**KIRKLEES METROPOLITAN COUNCIL
INVESTMENT & REGENERATION SERVICE**

Reference No: 2021/62/92998/E

Site Address: 1, Swincliffe Gardens, Birkenshaw, BD19 4BR

Description: Erection of single storey rear extension, increase in roof height and exterior alterations

Drawing Title
 FLOOR PLANS

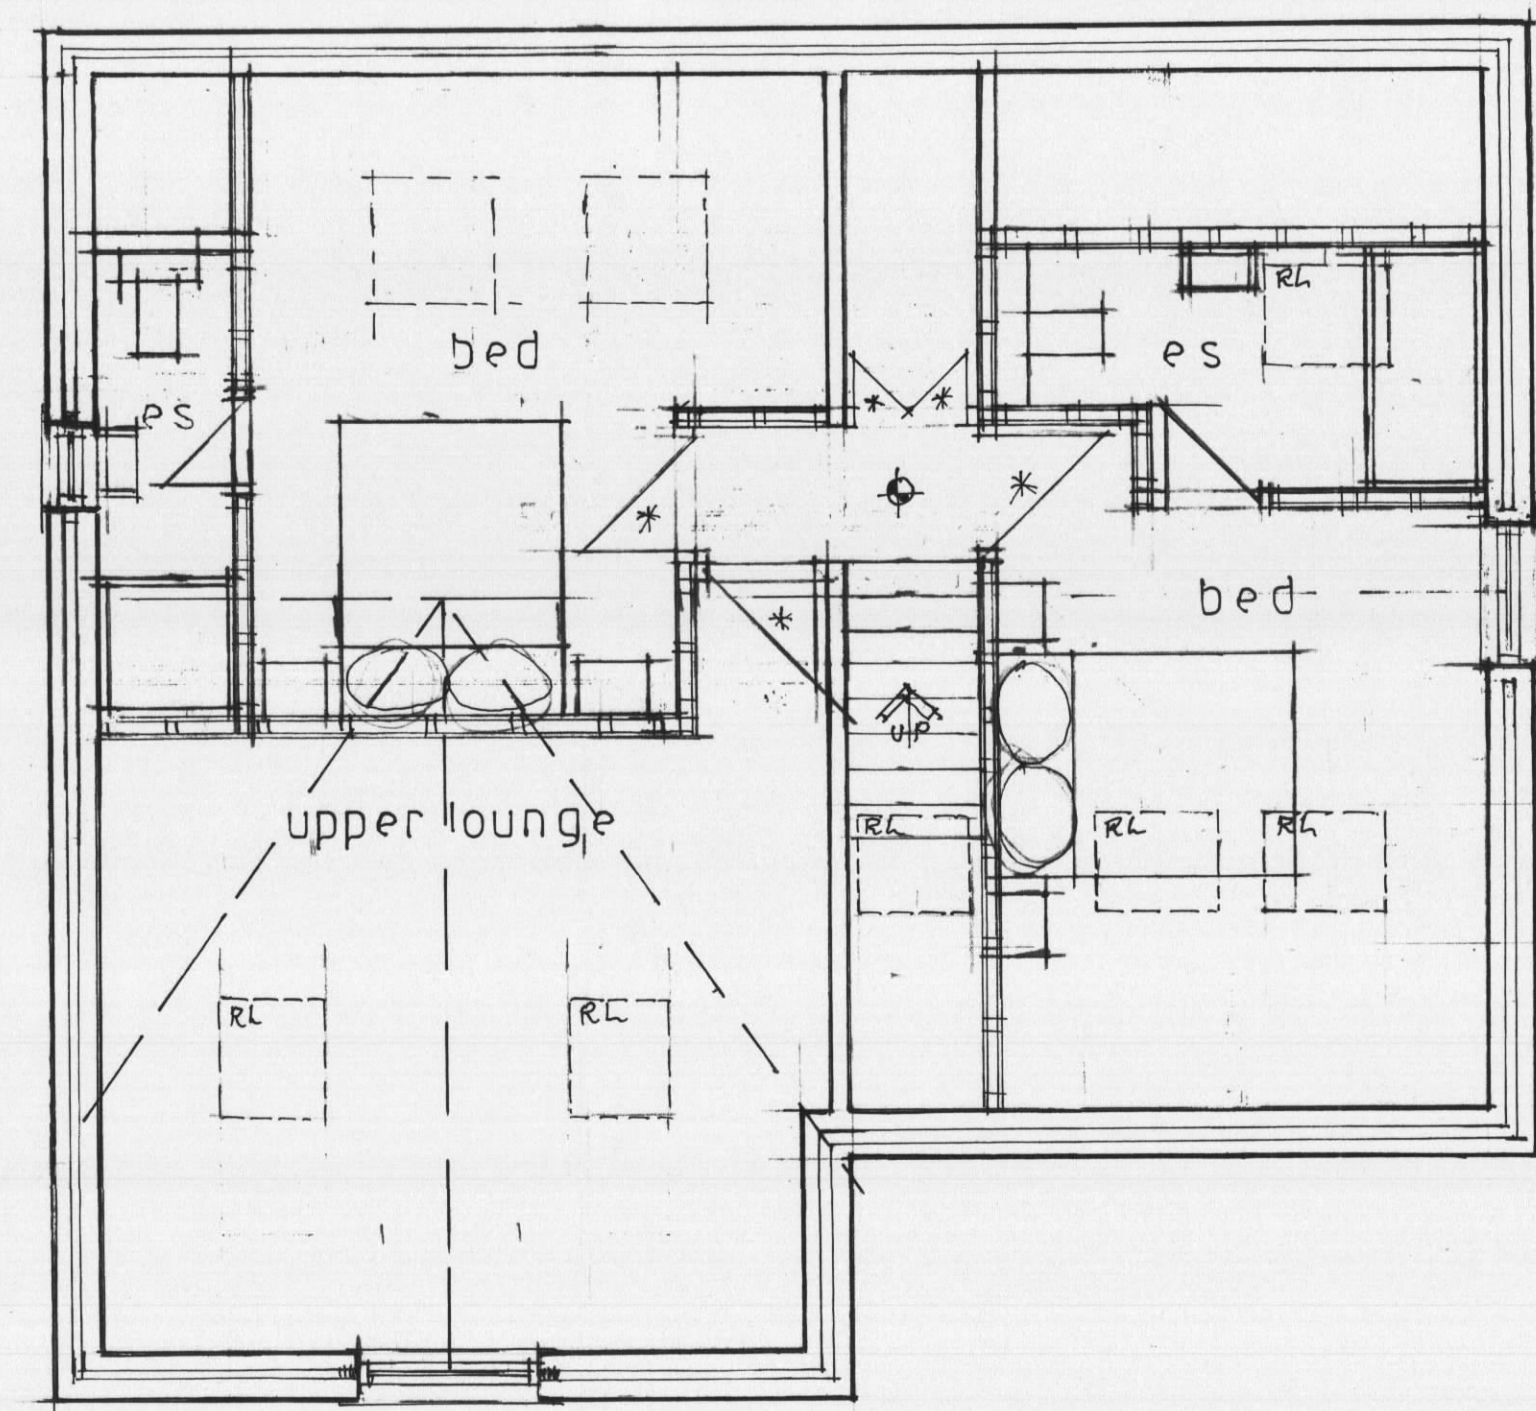
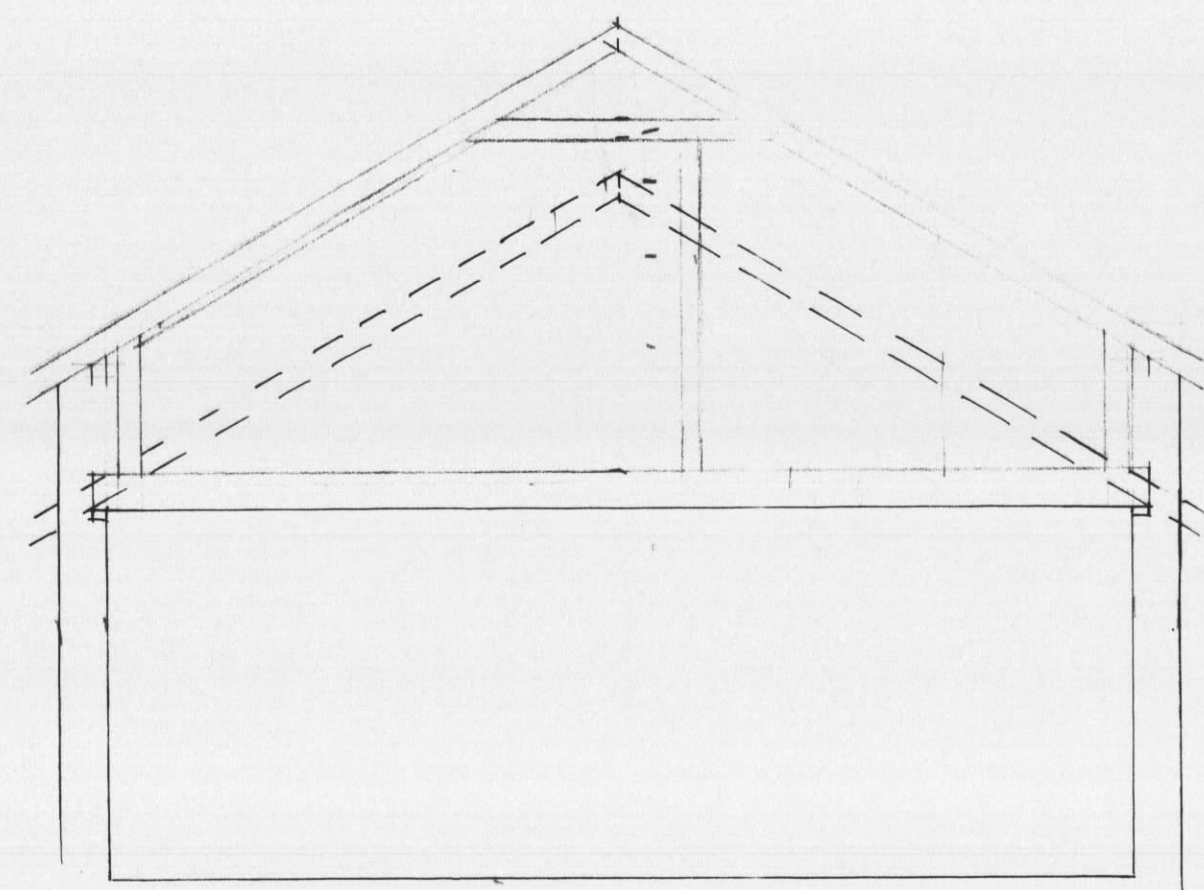
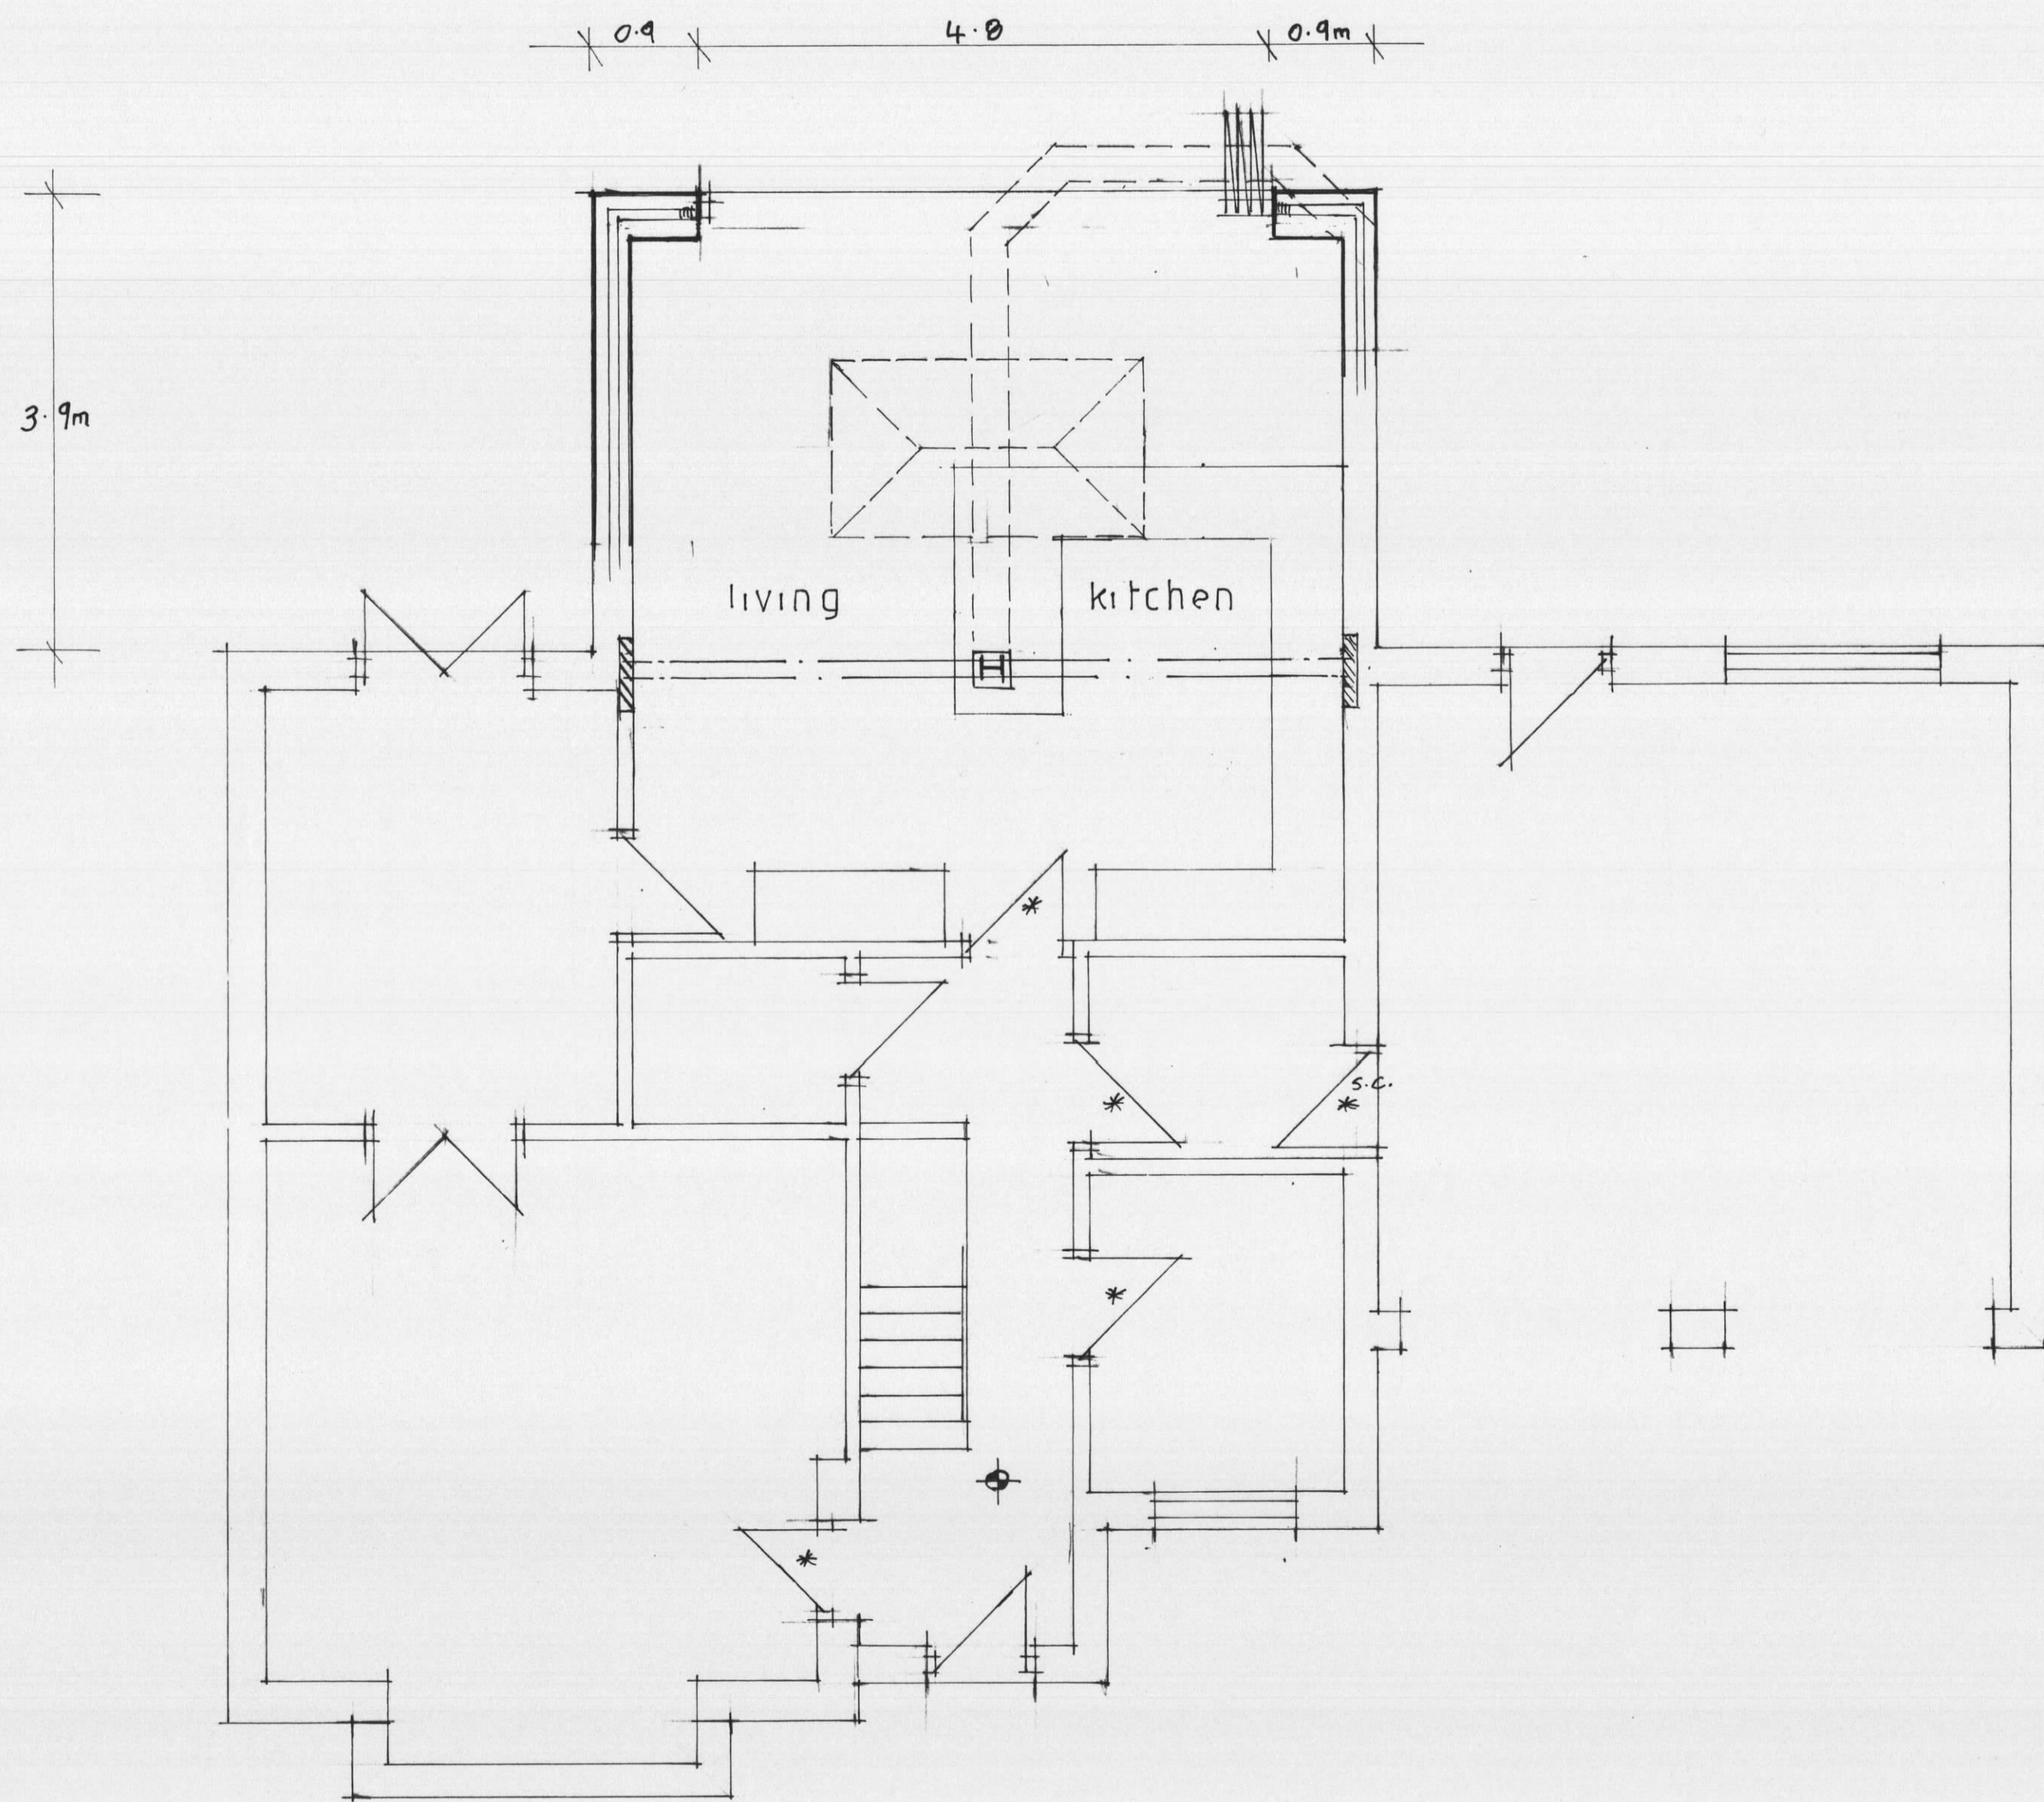
The proposed north facing gable en suite window would be conditioned to be obscure glazed.

Some 16m would be retained from the south east facing side elevation window, shown serving the bedroom to the nearest property, itself a side elevation. This is acceptable in regard to the SPD on house extensions.

3. The second floor (shown as 'roof plan') shall not be occupied until the second floor window at the north facing side elevation, shown serving the en suite, is glazed to a minimum of level 3 on the Pilkington scale of obscuration or
